Our ref: NO/2022/114950/04-L01
Your ref: 3/2022/1003
Date: 06 April 2023

**DISCHARGE OF CONDITION 21 (COMPENSATORY STORAGE) FROM PLANNING PERMISSION 3/2021/0205.
LAND AT NEDDY LANE, BILLINGTON, BB7 9LL**

Environment Agency position

Title
Pre & Post Development Floodplain
Sheet 6 of 8

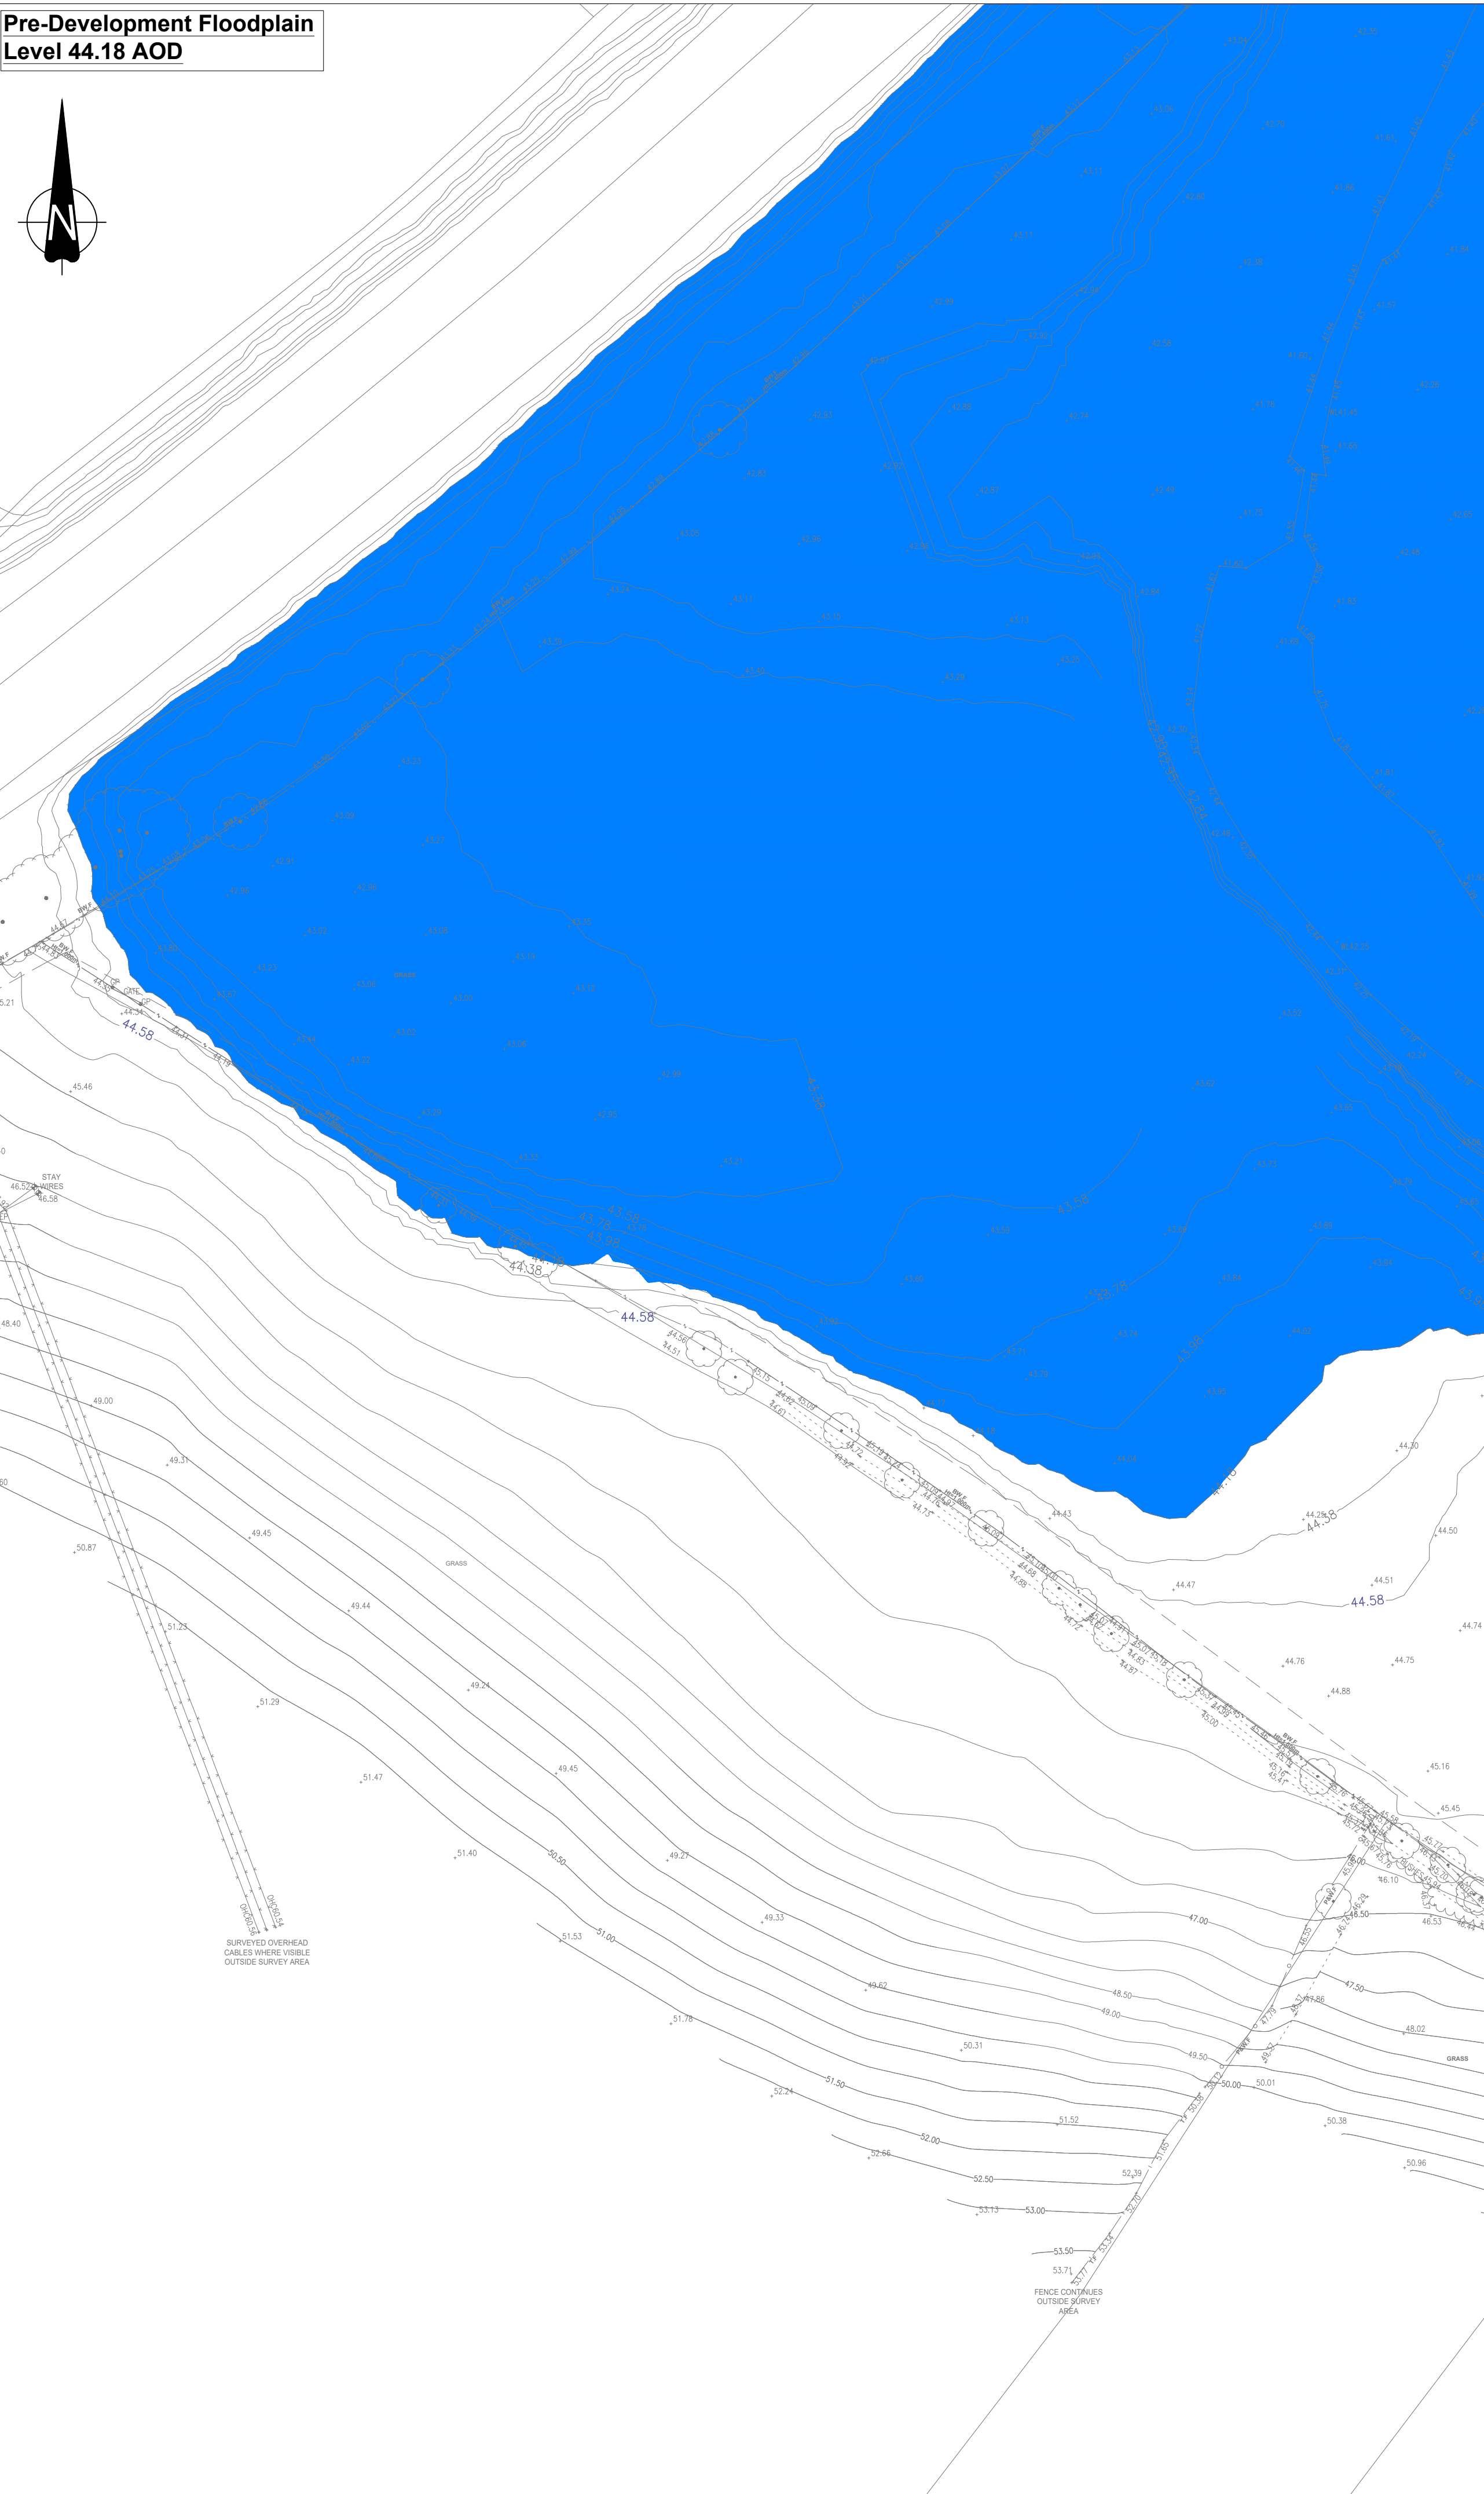
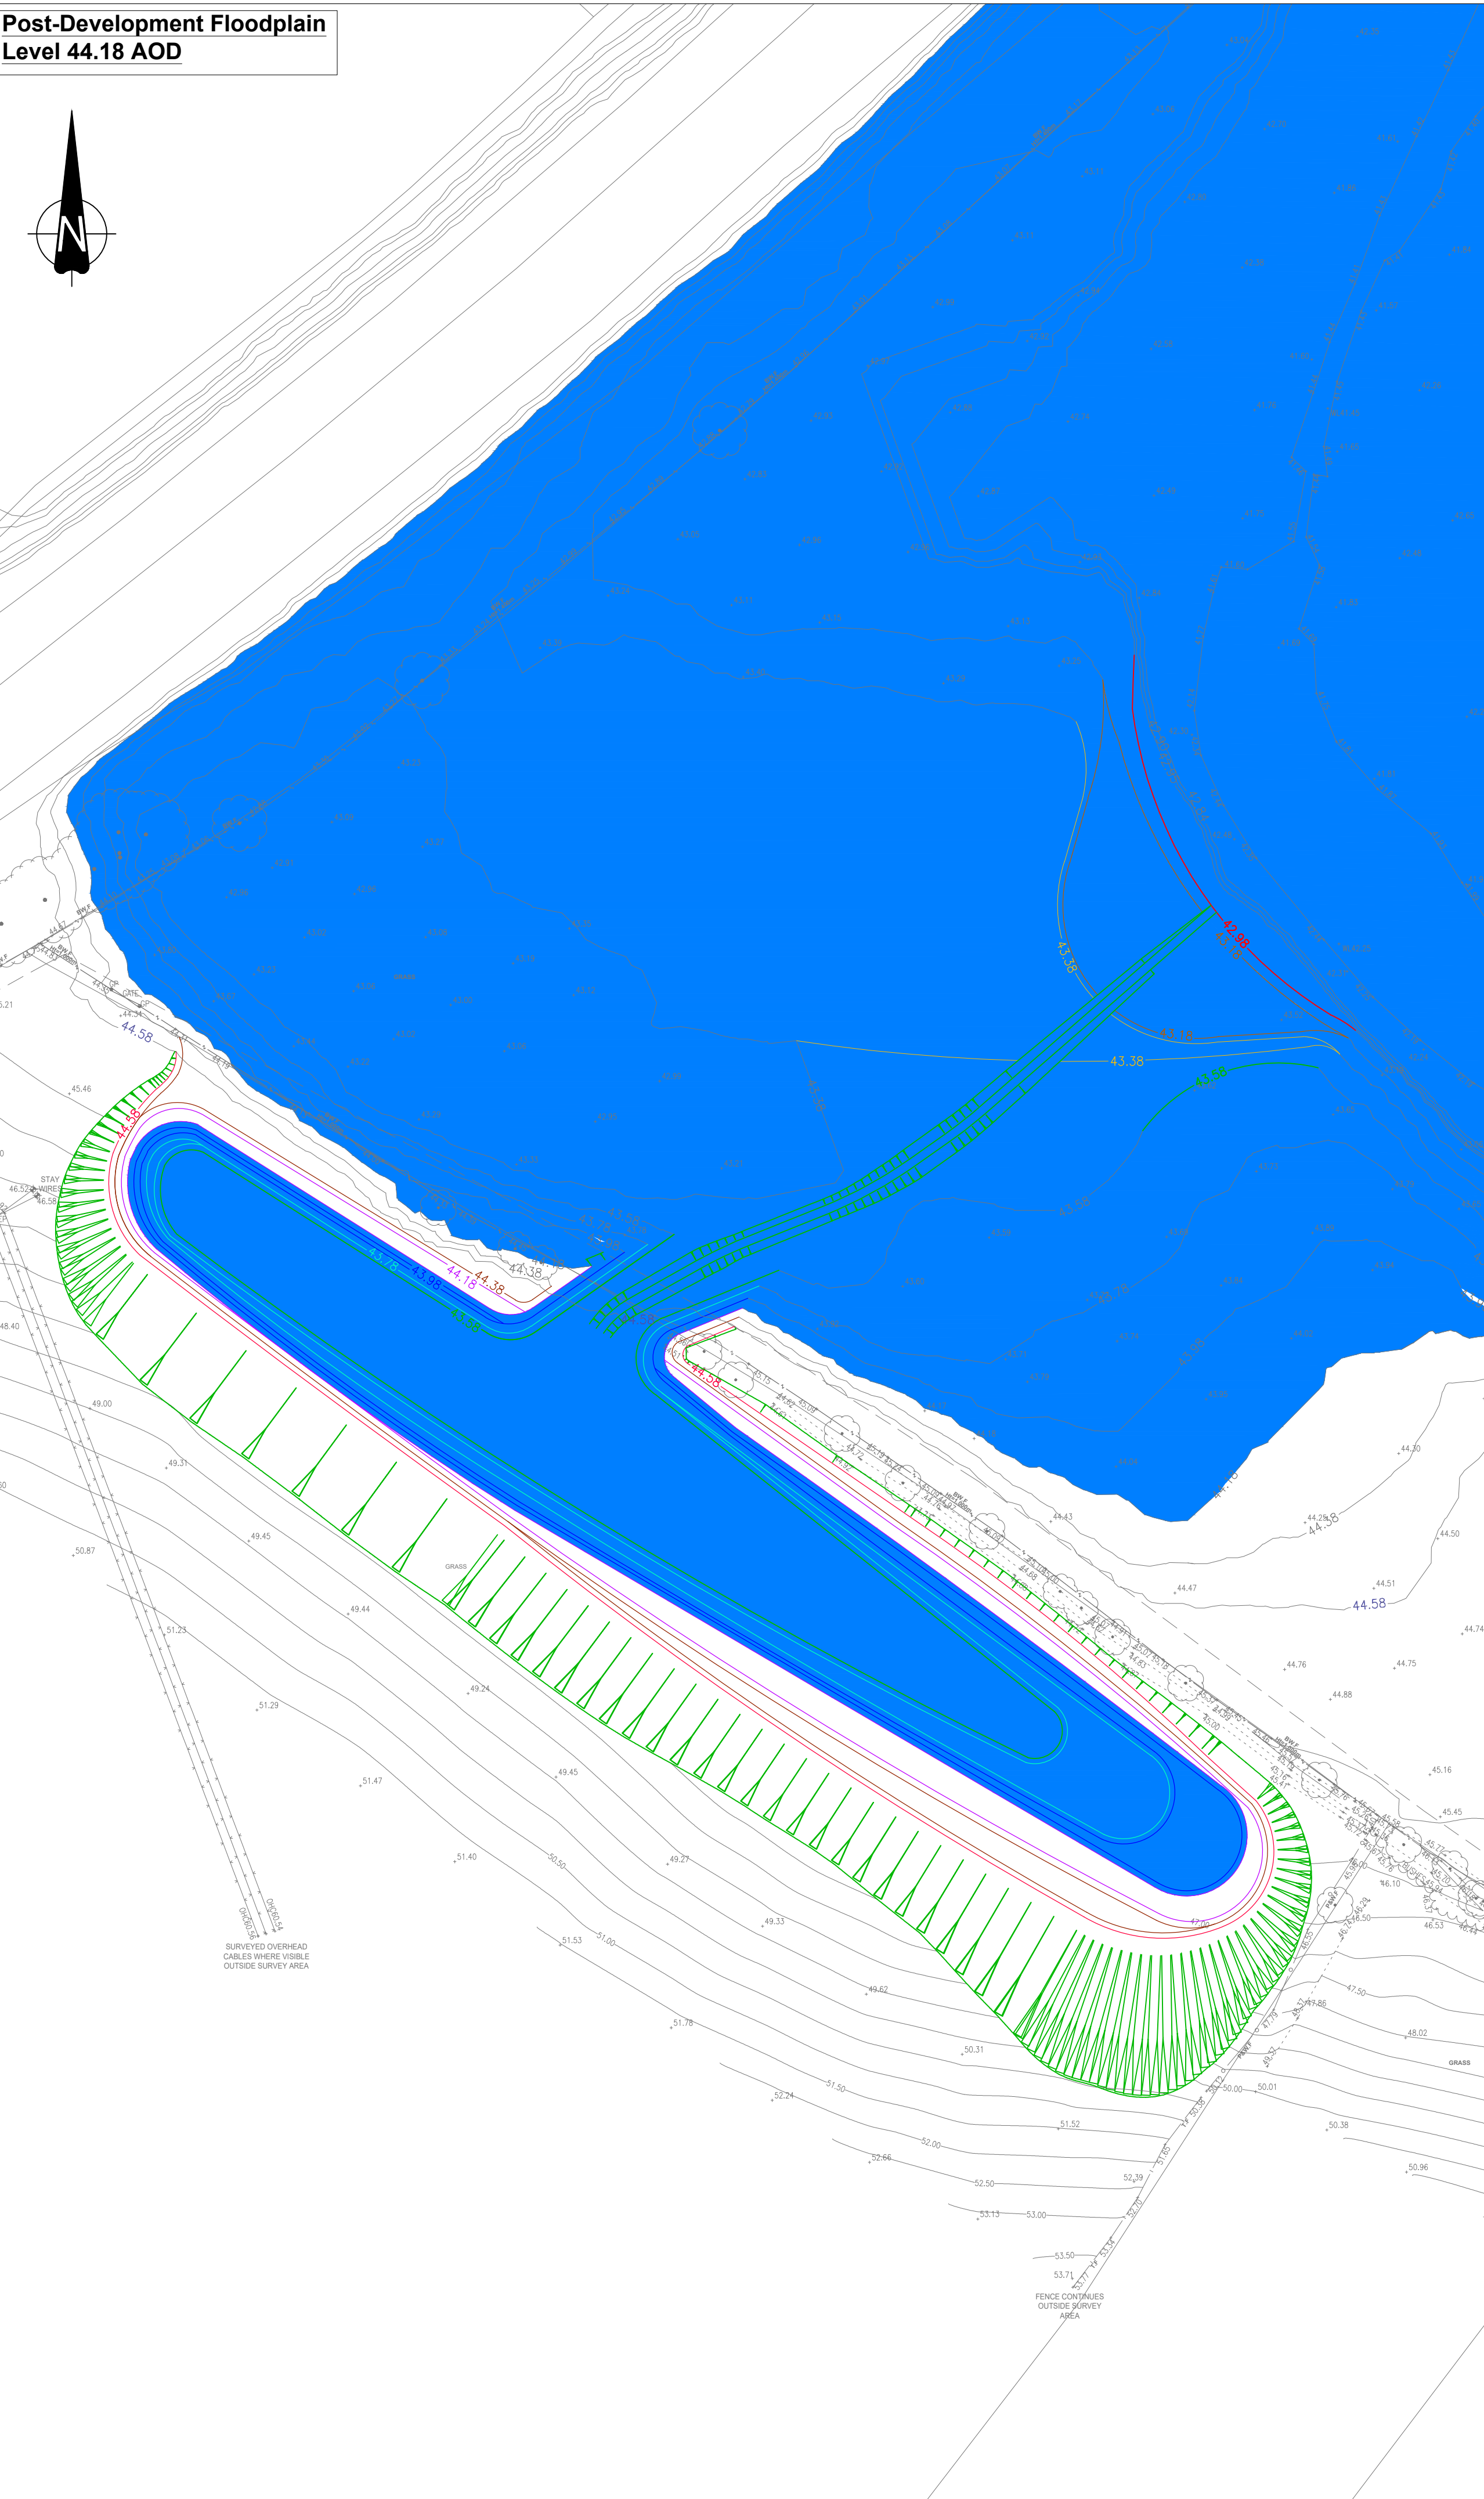
We have reviewed the details submitted to the LPA on the 21st March 23. We assume that the drawings are intended to show how flood water will propagate into the proposed flood storage area at 200mm increments to provide the required 'level for level' compensatory storage required for the proposed development platform.

The drawings do not appear to be derived from 2d hydraulic modelling, but rather an exercise in colour filling the relevant contour polylines. Therefore, we remain very concerned that the proposals are being progressed along an engineering cut and fill basis. Unfortunately, this means that there is still insufficient information regarding how the compensatory storage area will fill and drain during and after a flood event. As the submitted details do not satisfy the concerns outlined in our letter of 3 March 2023, we are currently unable to recommend the discharge of condition 21.
